# **COUNTY COUNCIL'S RESPONSE TO CONSULTATION ON THE FOLLOWING DEVELOPMENT PROPOSAL**

**Application No:** 20/02083/OUT-2

**Proposal:** Outline - Erection of 14 two-storey dwellings

**Location:** Land north of Hempton Road and west of Wimbourne Close, Deddington

Land off Hempton Road, Deddington - ILLUSTRATIVE LAYOUT

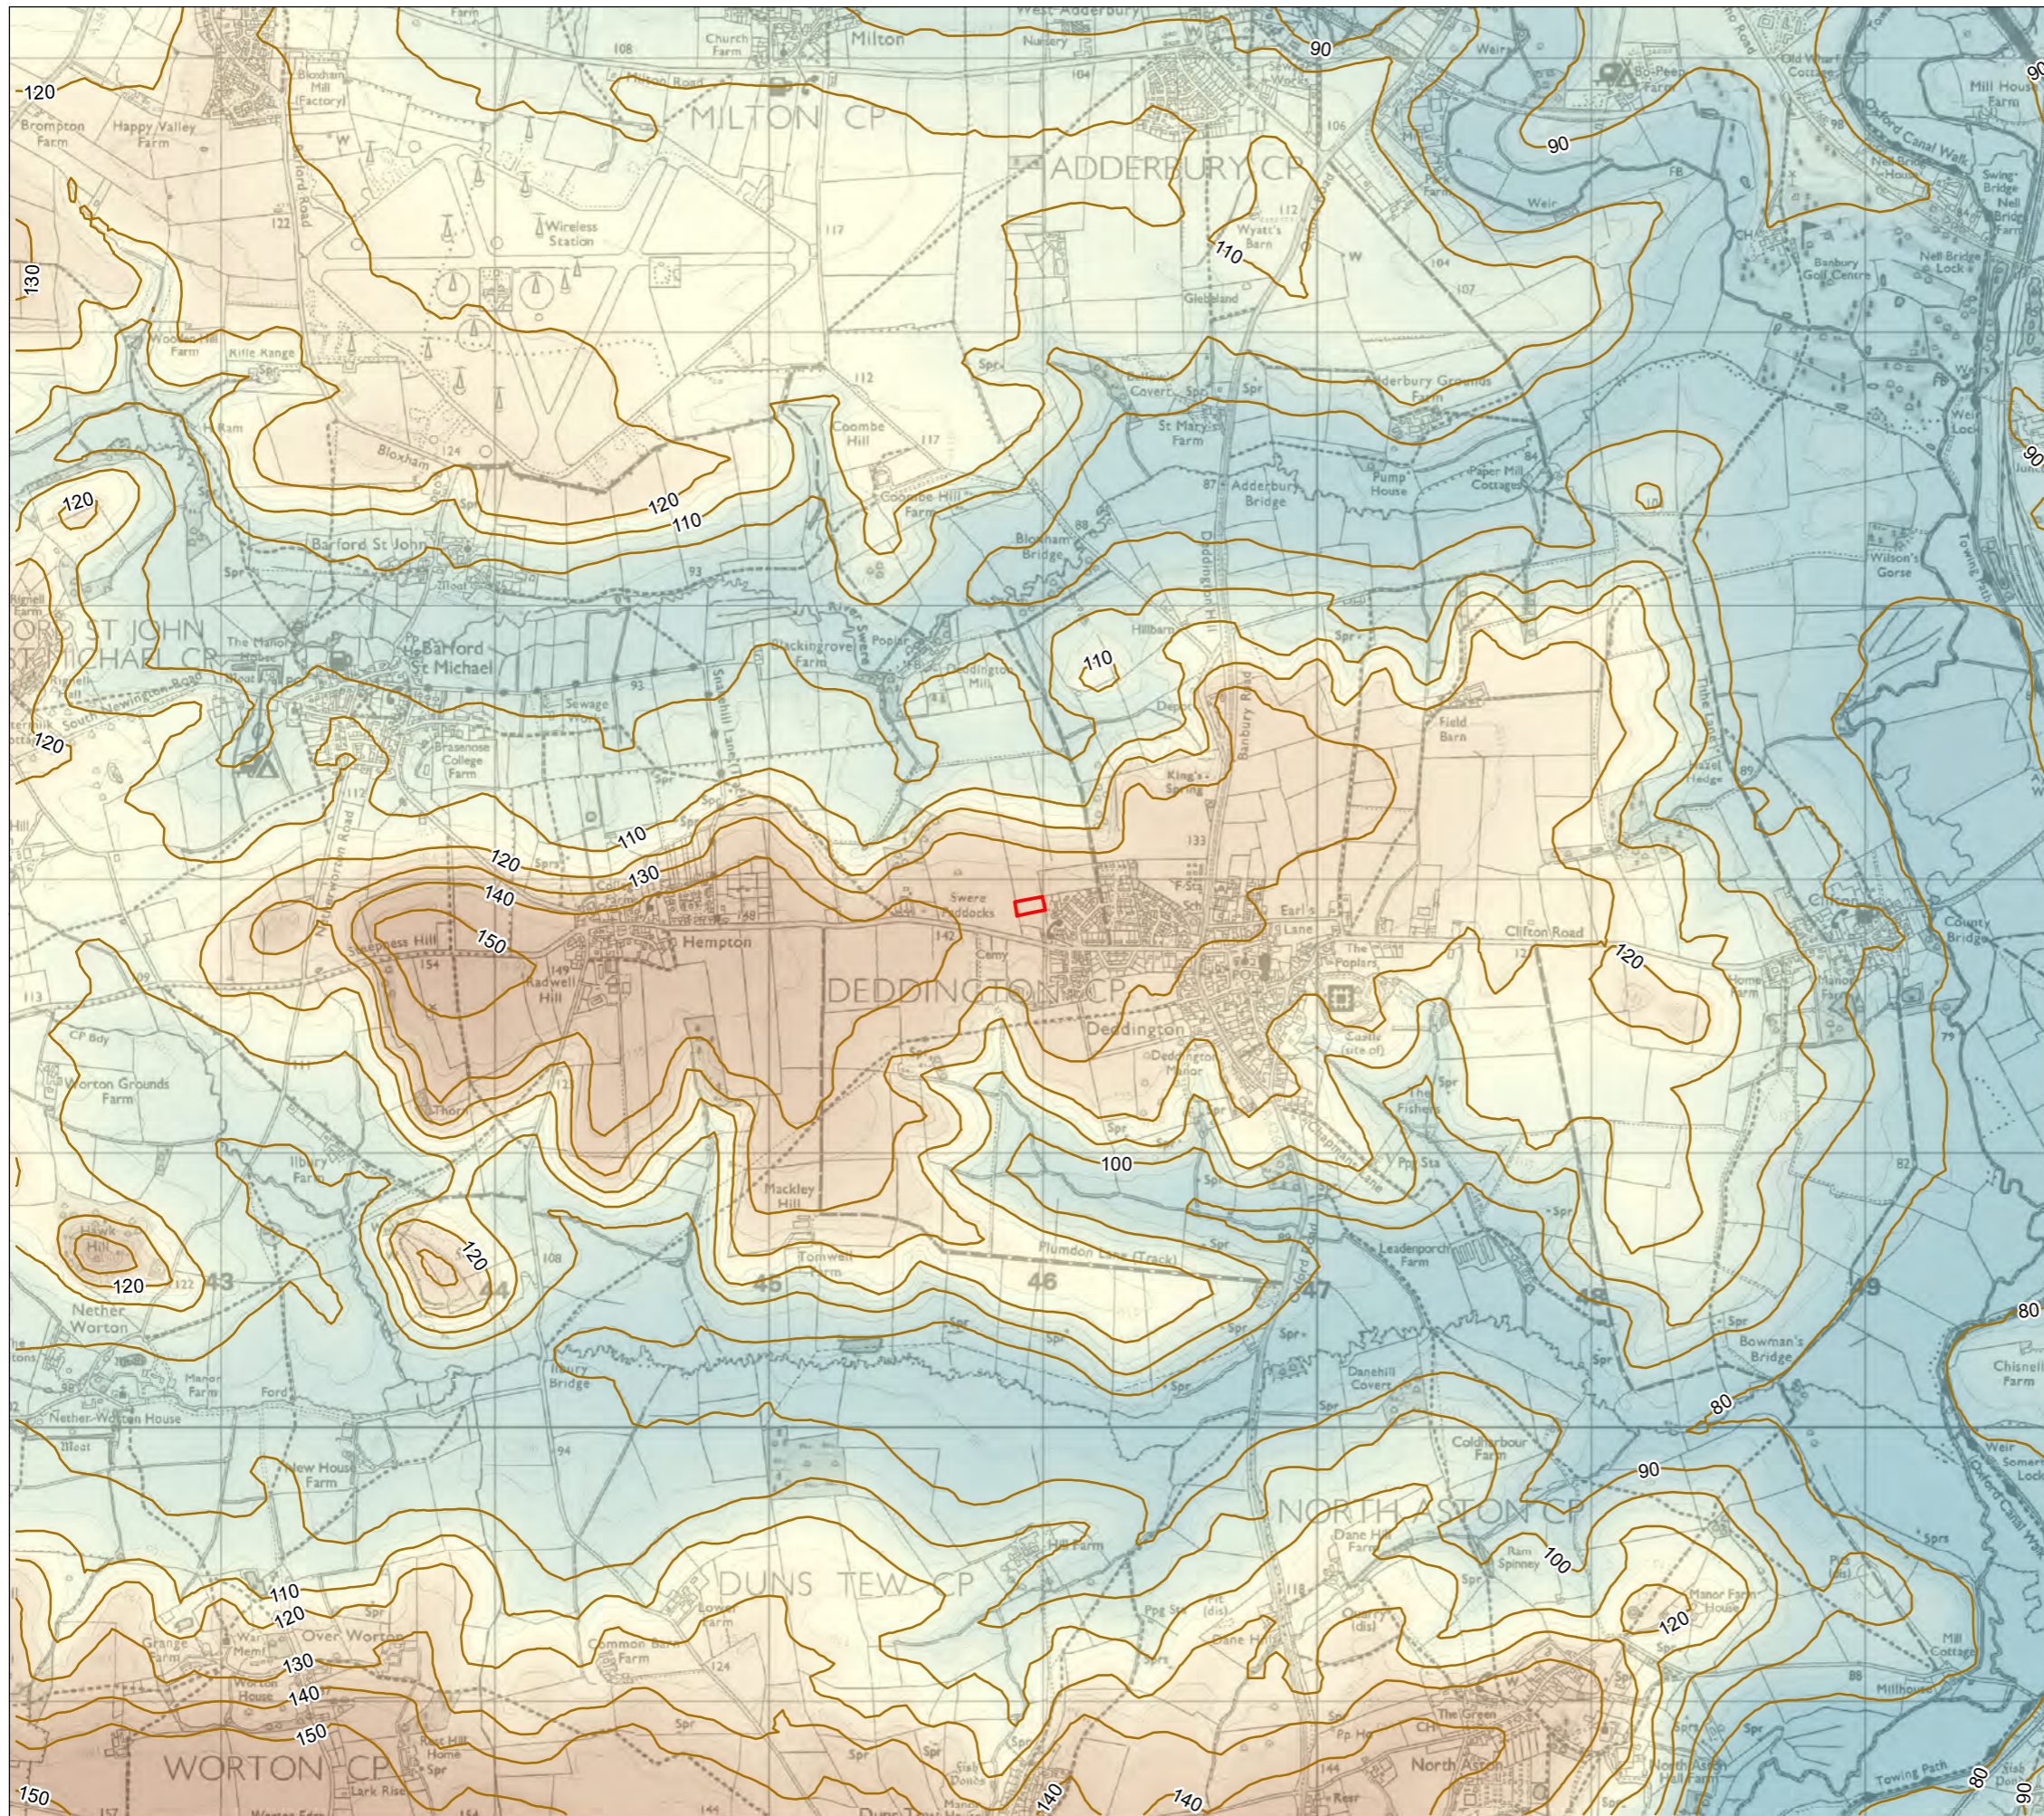
The revised Illustrative Masterplan now indicates four visitor parking spaces, where there were previously only two. These spaces must be at least 2.5m wide but scale to just 2.0m. If it is assumed that the housing mix is the same as before, there would ideally be at least five spaces. However, four of the dwellings also have garages and a least one plot has four off-road spaces, so there is an over-supply of allocated bays which means the overall provision is considered acceptable.

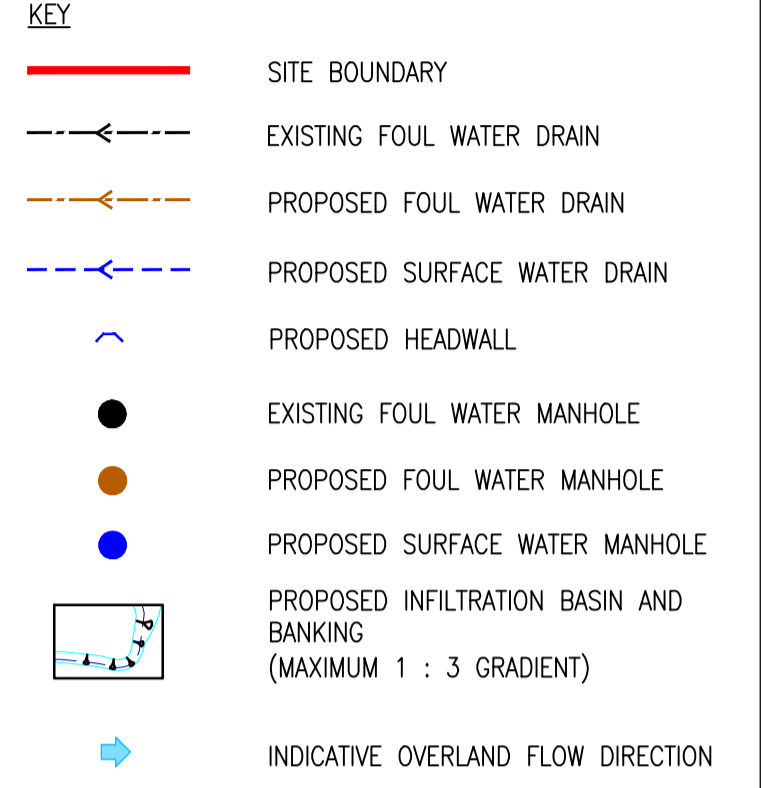
The applicant must submit a standalone proposed drainage strategy in accordance with latest national and local authority guidance. There is no evidence to show the existing additional pond can take extra discharge.

Applicant must provide calculation files clearly indicating how a gravity system is to be delivered with greenfield discharge rates.

The LLFA feel the below figures are above green-field run-off rates for the site

1:1 flow rate 63l/s

1:30 flow rate 146l/s

1:100 flow rate 230l/s
